Recommendation: Approval

Applicant: Mr Oswyn Murray

Proposal: Installation of 24 ground-sited solar panels in field

GLEBE FARM, SIBFORD GOWER, BANBURY, OX15 5RT

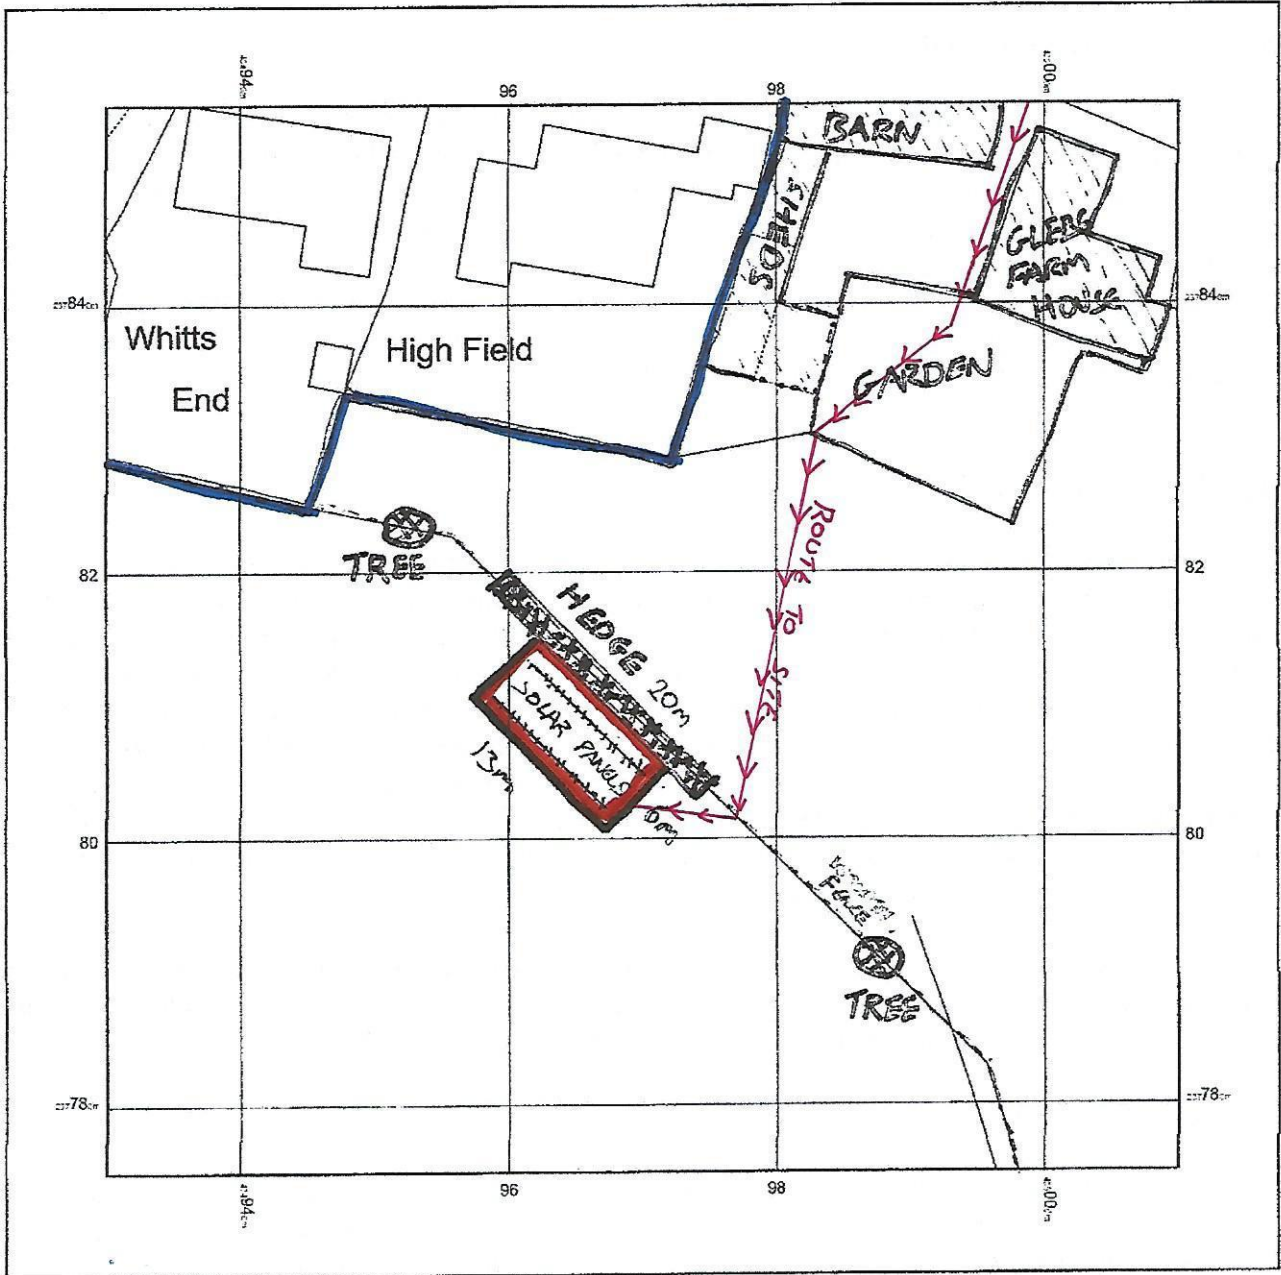
- 6.4. CDC Environmental Health - No objections
- 6.5. CDC Arboriculture (12.09.2022) - This application does not appear to affect any trees. The solar panels will be installed close to a hedge. Hedges grow. How are the applicants going to trim the hedge when it starts to cover the solar panels? From the block plan the panels will be abutting the hedge. Sufficient space should be left between the hedge and the solar panels so the hedge can be maintained.

- 6.8. CDC Ecology - With regard to the above application for installation of solar panels, I have no objections on ecological grounds to the principle of their installation in this location. My only comment would be that I cannot tell how close to the hedgerow they are due to be positioned and that they should be set back from it by at least 3m to allow there to be a buffer to the hedgerow for both management and wildlife to use the hedgerow base.

- 8.20. The Council's Ecology Officer (CE) has raised no objections to the principle of the proposal in this location on ecological grounds but advises that the proposed development should be positioned at least 3m away from the hedgerow to allow for a buffer between the development and the hedgerow for both management and wildlife to use the hedgerow base.

- 8.23. The Arboricultural Officer (AO) advised that the proposal does not appear to affect any trees, but that the solar panels would be installed close to a hedgerow and queried how the applicants were going to trim the existing hedge when it starts to cover the solar panels. The AO also mentioned that it appeared from the proposed plans the panels would be abutting the hedge and sufficient space should be left between the hedge and the solar panels to enable maintenance of the hedge.

- 8.21. The applicant has responded by confirming that the proposed installer has recommended an allowance of a buffer between the proposed development and the hedgerow for management, which is illustrated on the proposed plans (Block plan).

- 8.24. The applicant responded confirming that the proposed installer has recommended to allow for a buffer between the proposed development and the hedgerow for management, which is also illustrated on the proposed plans (Block plan).

- 8.25. The AO responded to the applicant's comments advising that the additional information was acceptable and wanted to ensure that access to the hedge had been taken account of. Having regards to AO comments, it is considered that the
